From: Ian Stocks [REDACTED] **On Behalf Of** FRS Water and Access
Sent: 04 November 2021 13:04
To: Planning.Responses <Planning.Responses@arun.gov.uk>
Subject: Hydrant condition - A/227/21/OUT Wilmington Arundel Road Angmering BN16 4ET

HYDRANT CONDITION CONSULTATION WITH PLANNING AUTHORITY

Planning Ref: A/227/21/OUT

Address: Wilmington Arundel Road Angmering BN16 4ET

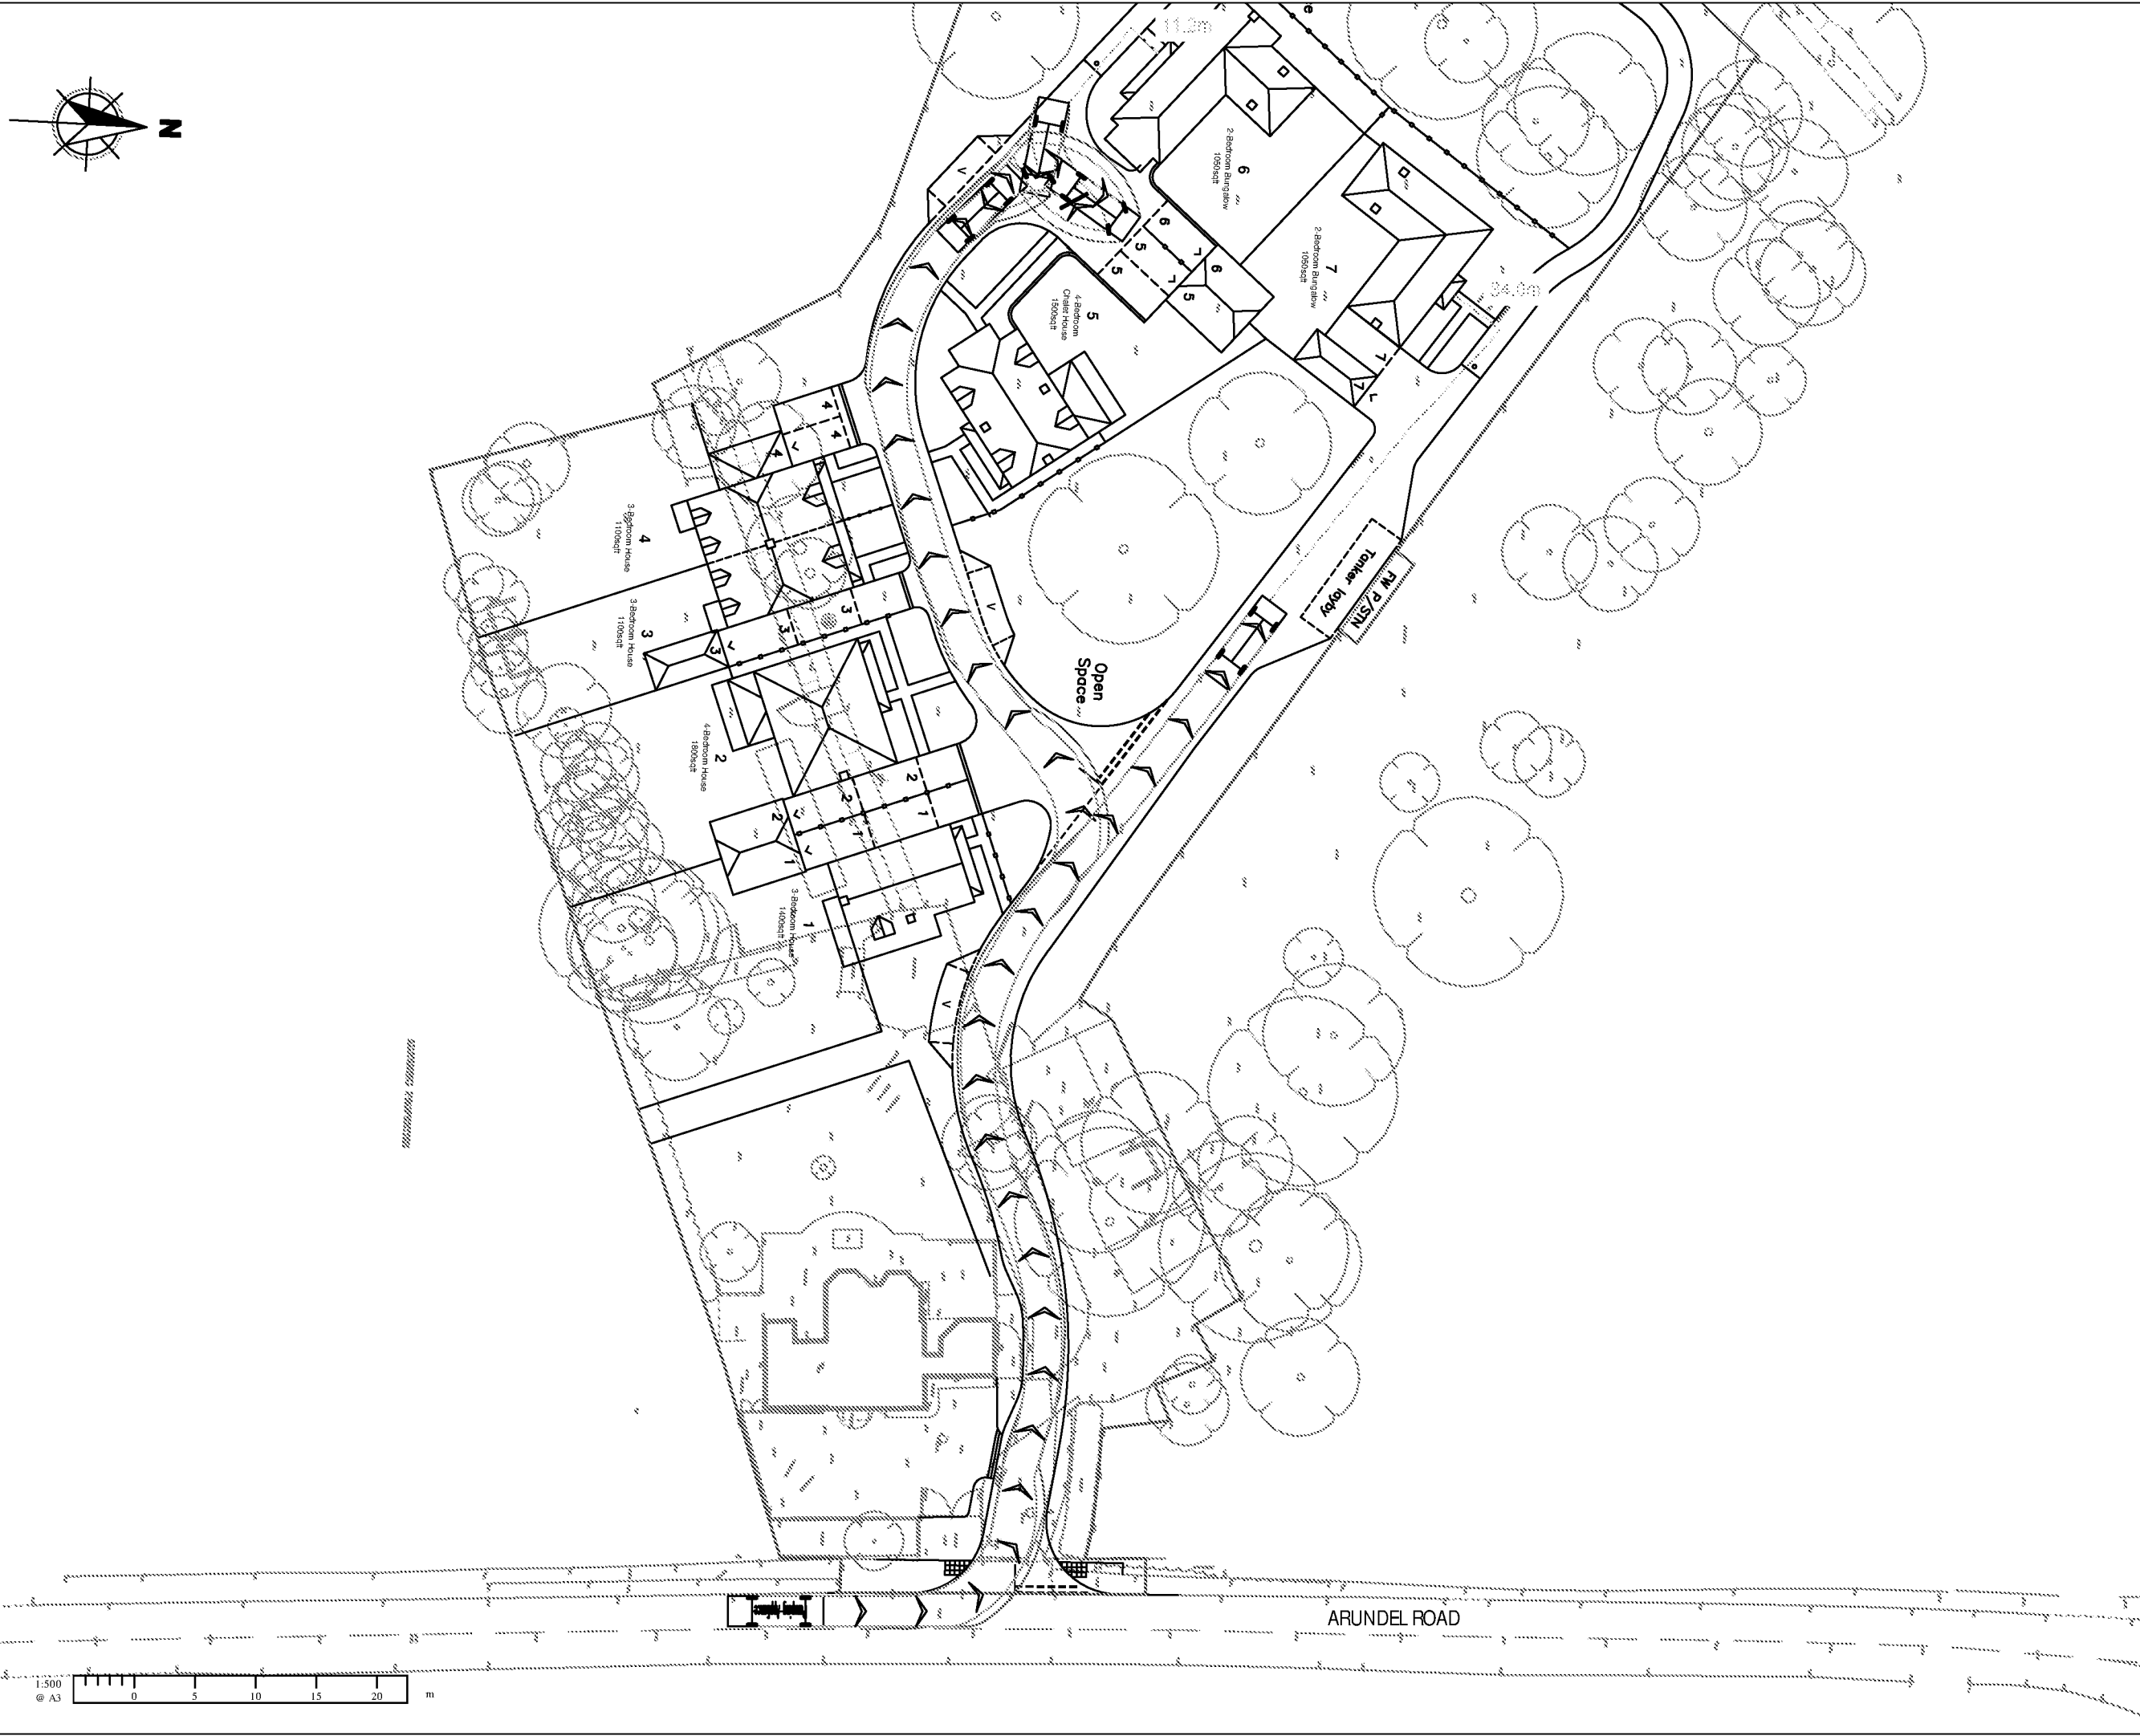
Evidence will also be required that Fire Service vehicle access meets with the requirements identified in Approved Document B Volume 1 2019 Edition: B5 Section 13, including Table 13.1 and diagram 13.1.
